Application by EPL 001 Limited: Stonestreet Green Solar Project (Application Reference: EN010135)

Responses to Section 51 Advice and Section 55 Checklist

Appendix 1- Responses to Section 51 Advice and Section 55 Checklist

Produced: RC Checked: Quod Date: December 2024 Version: 03

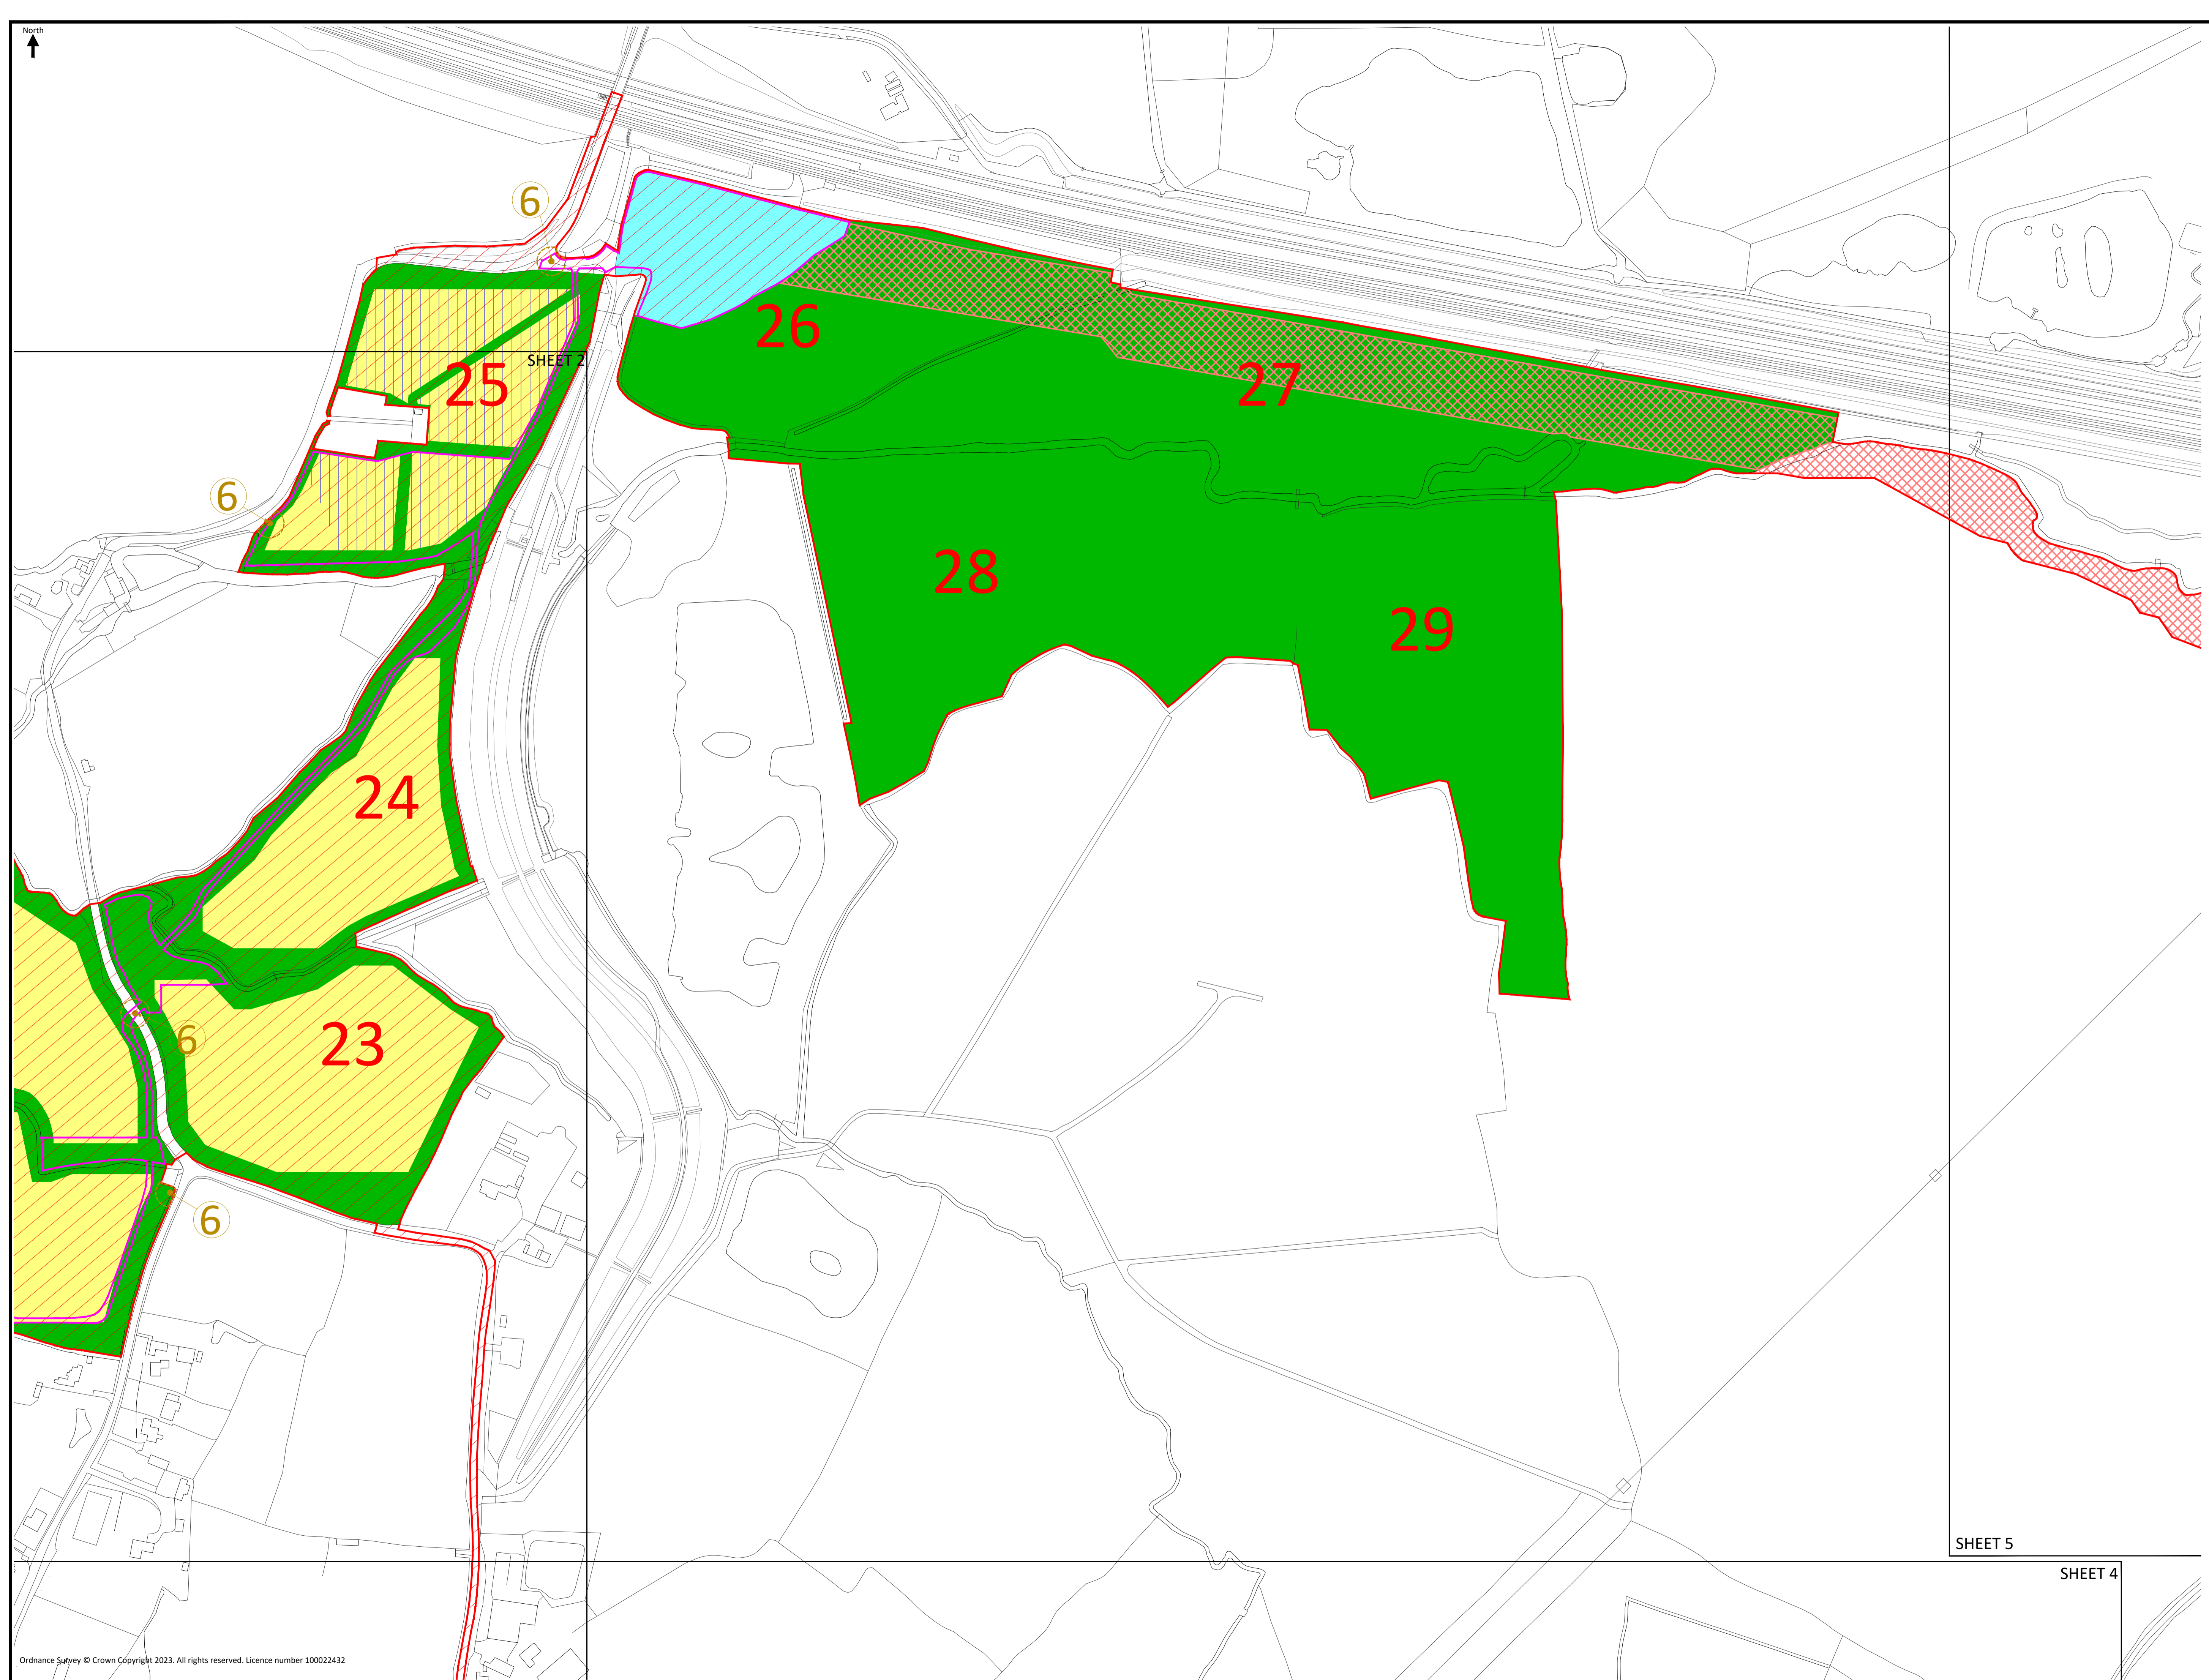
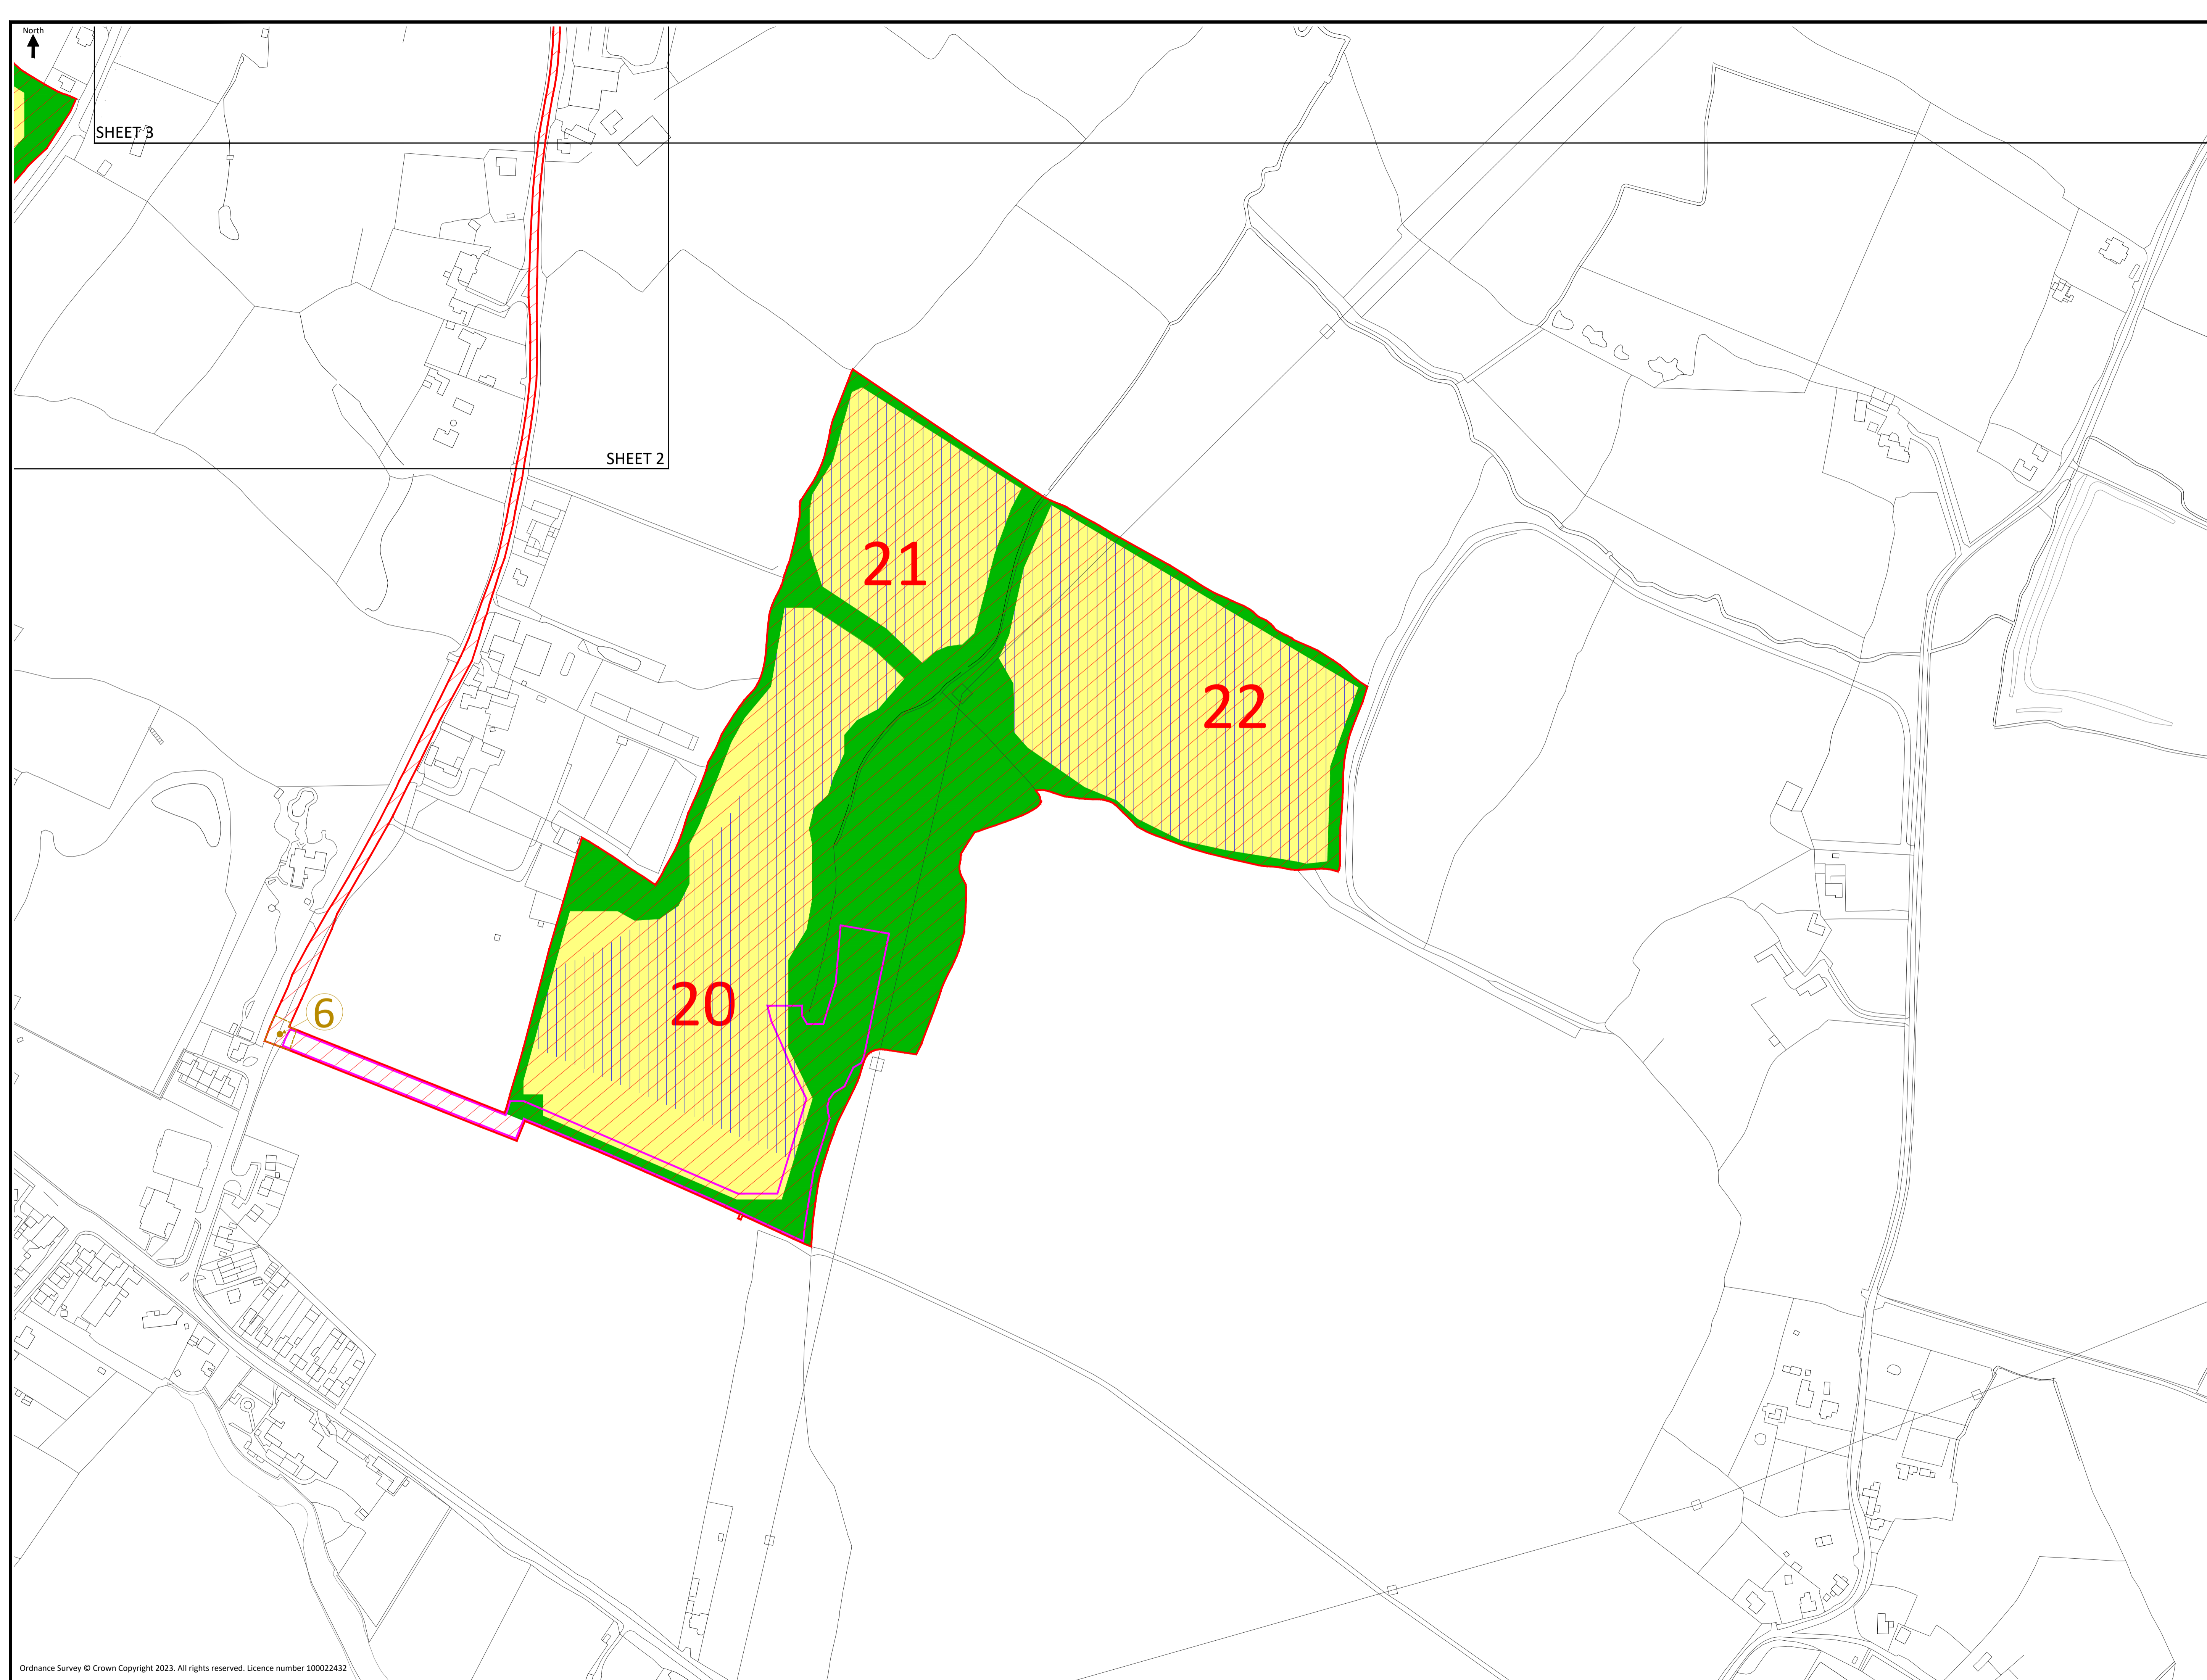
Section 51 Advice	Response
<p>The Works Plan (Doc 2.3) shows broad areas where the construction compounds could be located within Fields 8/9, 19, 20, 23, 25 and 26. The internal haulage road is also of a colour and design that is difficult to decipher from the remainder of the works that are shown on the Works Plan.</p>	<p><i>Goldwell Lane). Use of the internal haulage road for HGVs will avoid associated traffic, noise and other disruption to local road users and residents compared to the use of the local road network.</i></p>
<p>(Doc. 2.7) Illustrative Landscape Drawings – Not for Approval -There appears to be inconsistency on Section 4 Quested Cottage and Habitat Area– A proposed hedgerow is shown in a bold colour whereas ‘Proposed Tree and Shrub Planting’ are shown in fainter colours.</p>	<p>The appearance of the proposed planting on Section 4 is intentional. The bolder coloured vegetation is shown where the section line cuts through a feature, whereas the faded vegetation is in the background and shown in elevation. This has been done to provide depth perception.</p>

<p>We would advise that either the colour for the internal haulage road is amended to aid clarity or that separate plan is provided that shows both the location of the internal haulage road and the proposed construction compounds. We would also advise that clarification is provided as to the locations of the construction compounds within the Fields given their positioning could have an impact on the environment and amenity.</p>	<p>As noted above, the Work Plans (Doc Ref. 2.3) have been amended so that Work No. 7 is shown as a solid pink line. The line weight has been increased to make it easier to read alongside other Works.</p> <p>The maximum extents of the construction compounds (Work No. 7) are shown on the Work Plans (Doc Ref. 2.3) and then described in Chapter 3 of the Environmental Statement (Doc Ref. 5.2). See extracts below:</p> <p><i>“3.11.2 Two Primary Construction Compounds / primary decommissioning compounds will be located in Fields 25 and 26 as shown as Work No. 7 on the Works Plans (Doc Ref. 2.3)...”</i></p> <p><i>“3.11.4 Four Secondary Construction Compounds will be located in Fields 8/9 (adjacent to Bank Farm), 19, 20 and 23 as shown on the Works Plans (Doc Ref. 2.3).”</i></p>
